Project Number SSI 6878
Major Projects Assessment
GPO Box 39
SYDNEY NSW 2001

RE: ALBION PARK RAIL BYPASS

# Map 3 - Southern Interchange

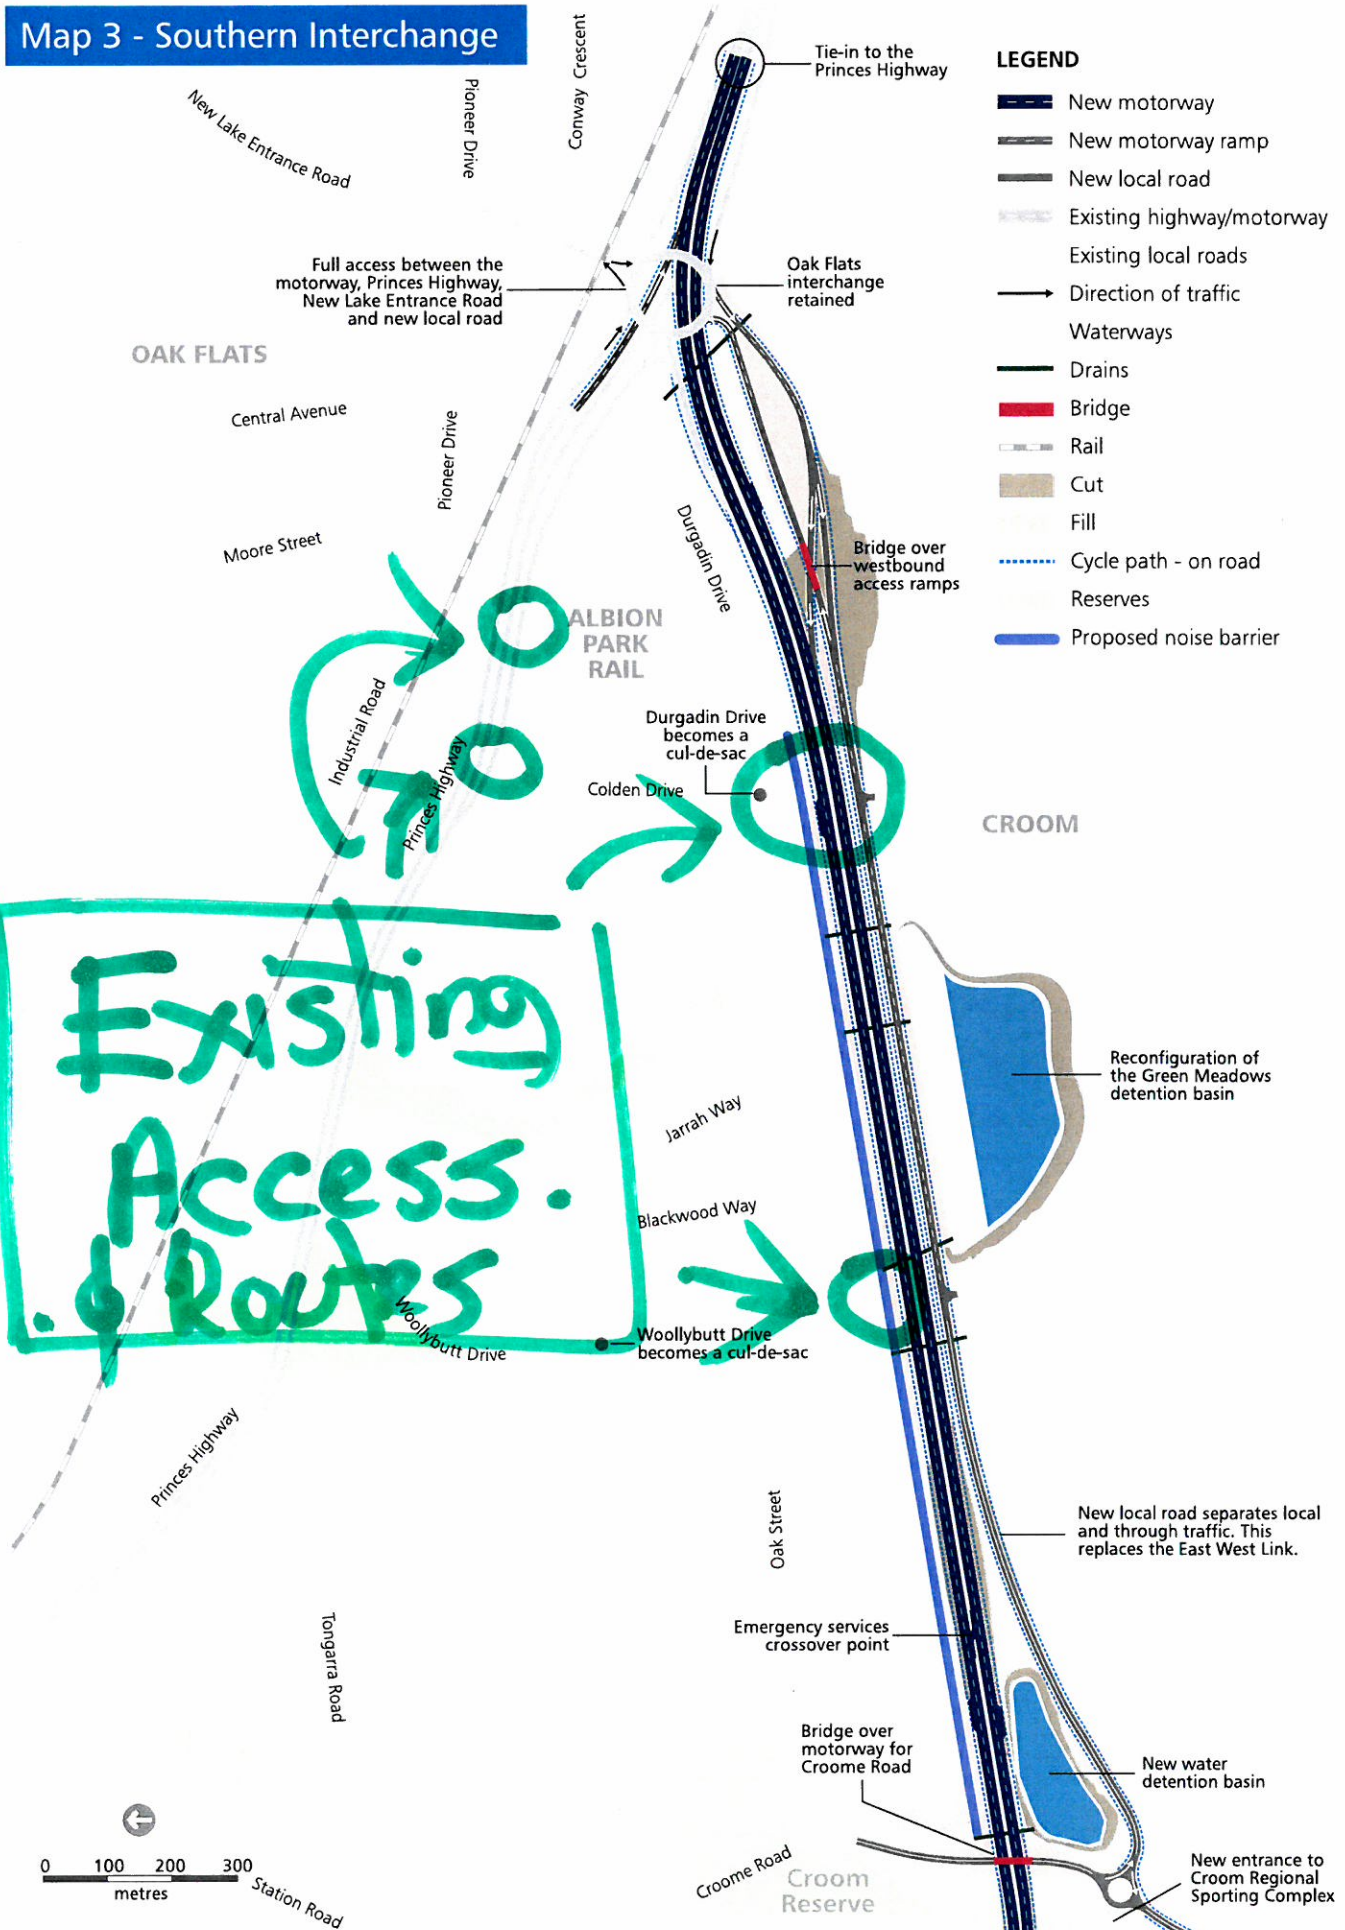
The Albion Park Chamber of Commerce (The Chamber) still maintains that the ramps shown on the plan and marked "*ramps may not be needed until a later stage*" should be constructed at the time the bypass is built.

The Chamber does not accept that the construction of the ramps is tied in to the construction of the Tripoli Way Bypass. We believe that this is nothing more than spin on behalf of the RMS to avoid having to build these ramps when the Bypass is constructed.

If the ramps are not built now, they will not be built.
